CITY OF ALBUQUERQUE

Re: ASI
4500 Paseo Del Norte NE
30-Day Temporary Certificate of Occupancy
Transportation Development Final Inspection
Engineer's Stamp dated 7-14-21 (D17-D110)
Certification dated 01-26-22

Based upon the information provided in your submittal received 01-20-22, Transportation Development has no objection to a 30-day Temporary Certificate of Occupancy based. This letter serves as a "green tag" from Transportation Development for a 30-day Temporary Certificate of Occupancy to be issued by the Building and Safety Division.

TCL

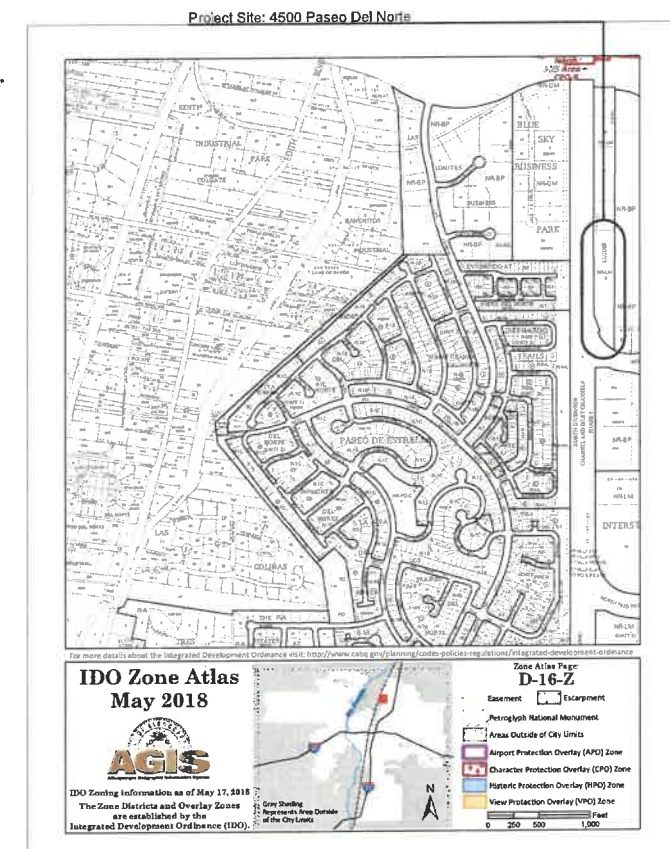
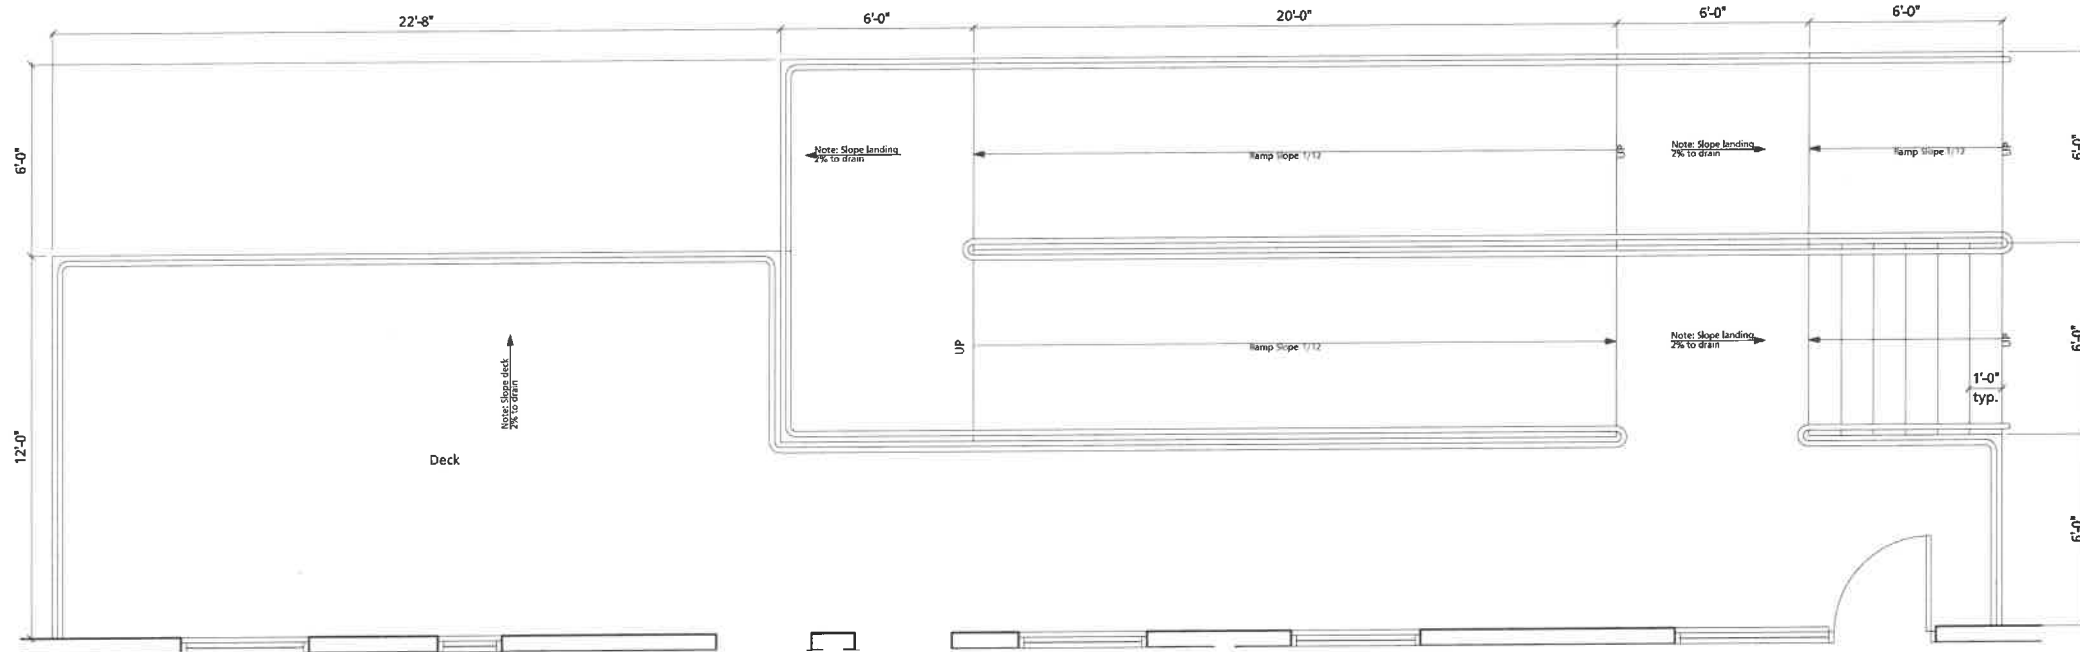
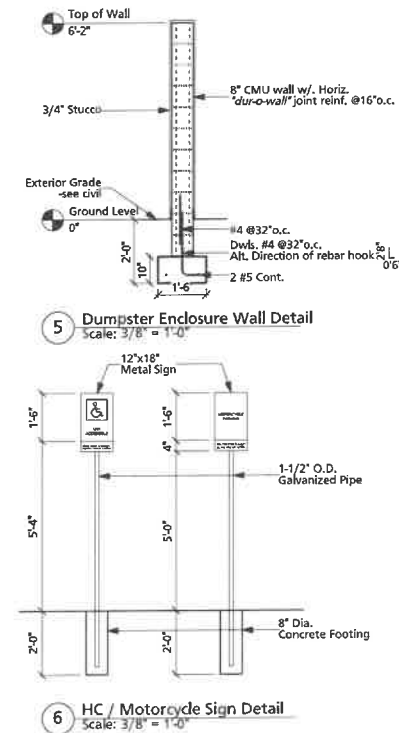
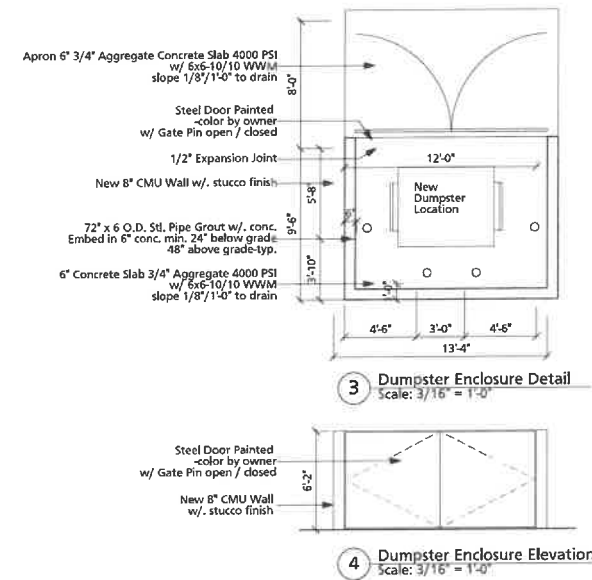
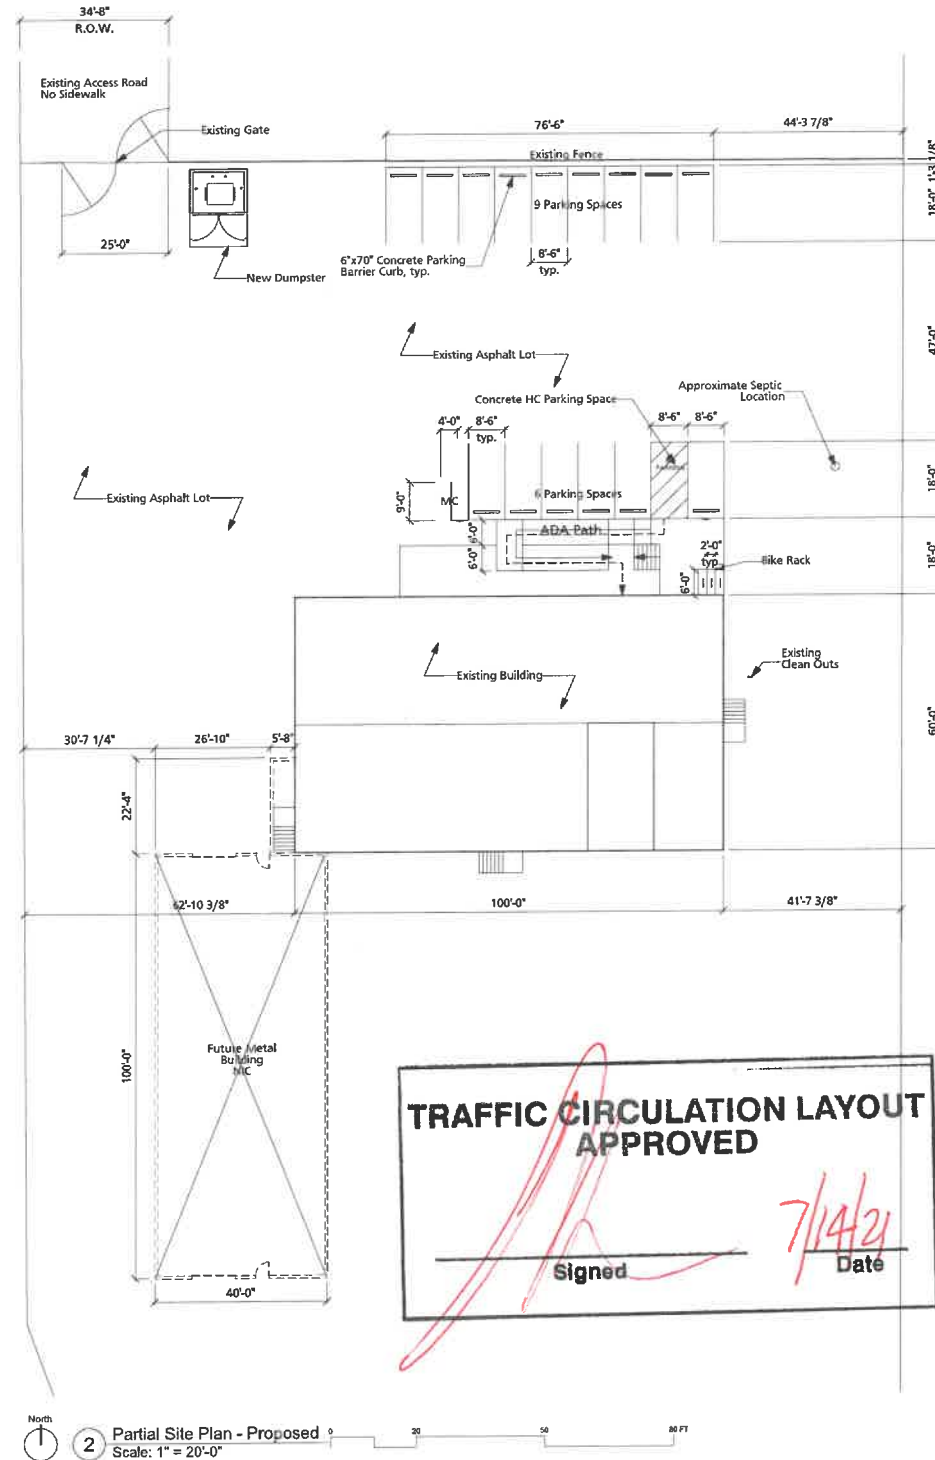
- Due to Bicycle parking requirement, you need to provide one more bicycle Rack.
- Provide "MC" pavement marking for each Motorcycle parking space.
- Remove construction equipment, porta potties and debris from site.

Once these corrections are complete, email pictures & redlined TCL plan showing the changes to PLNDRS@cabq.gov, and malnajjar@cabq.gov for release of Final CO. If you have any questions, please contact me at (505) 924-3675.
